# CITY OF ALBUQUERQUE

PLANNING DEPARTMENT – Development Review Services

July 15, 2014

RE: **Anasazi Ridge, Unit 3**  
**Drainage Report, and Grading and Drainage Plan**  
**Engineer's Stamp Date 6-19-2014 (File: A10D002G)**

CITY PROJECT NO. **XXXXXX** ZONE MAP NO. **A-10-Z** SHEET **1** OF **2**

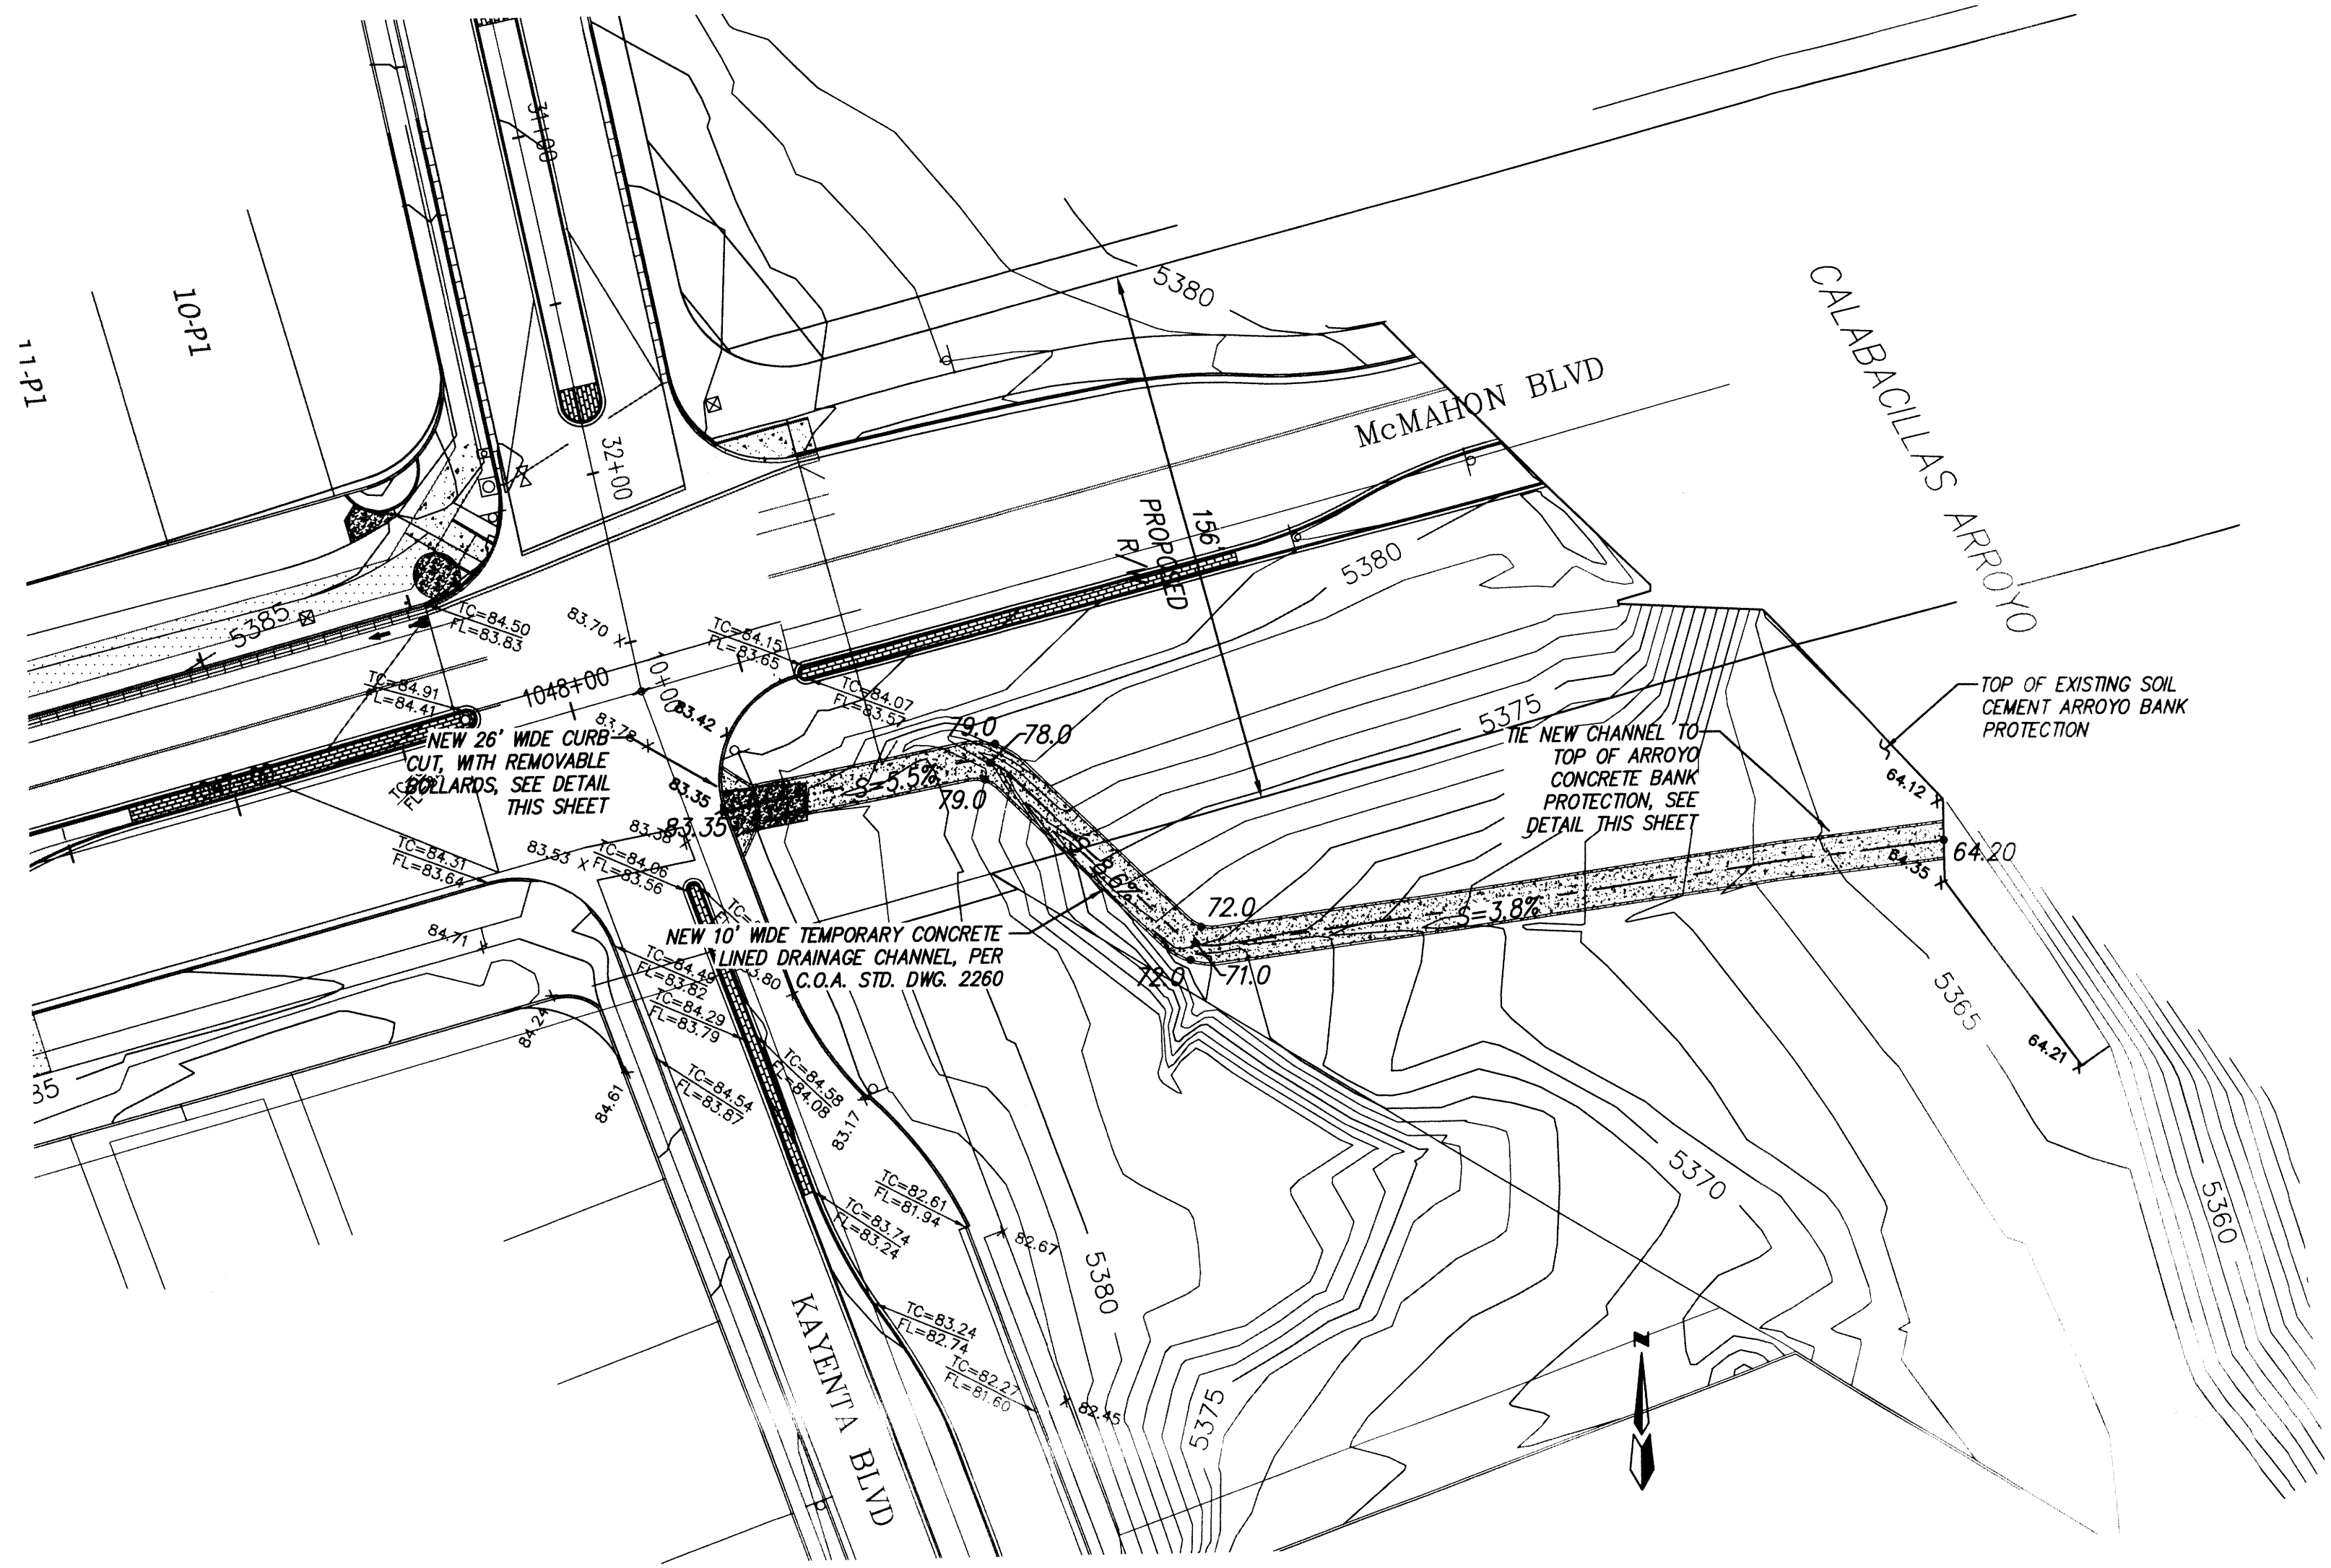
- Street depth is high, show that at least one driving lane is free of discharge.
  - what is the depth of flow at the valley gutters crossing Kayenta? Do the valley gutters have enough capacity to convey 44cfs flows to the 26' wide curb cut?

3. Drainage Report for the Seville Subdivision- Unit 7 (Wilson & Co, 2003) states that the storm drain system was designed to pick up some developed flows from this subdivision and enters through lot 23-P1. It is recommended that this flow path be considered in order to reduce the runoff into the street and crossing Kayenta Ave. It will also reduce the number of sidewalk required, as 6 culverts in series are not desirable.

4. Water harvesting pond is upstream from the runoff, and cannot capture first flush. The first flush is intended to capture *developed* runoff, to comply with EPA requirements.

5. Since the status of Lot 9 will change, the street stub provided to Lot 9 will also change, and may affect the drainage scheme.
6. Show grade contours beyond property boundary to the south.
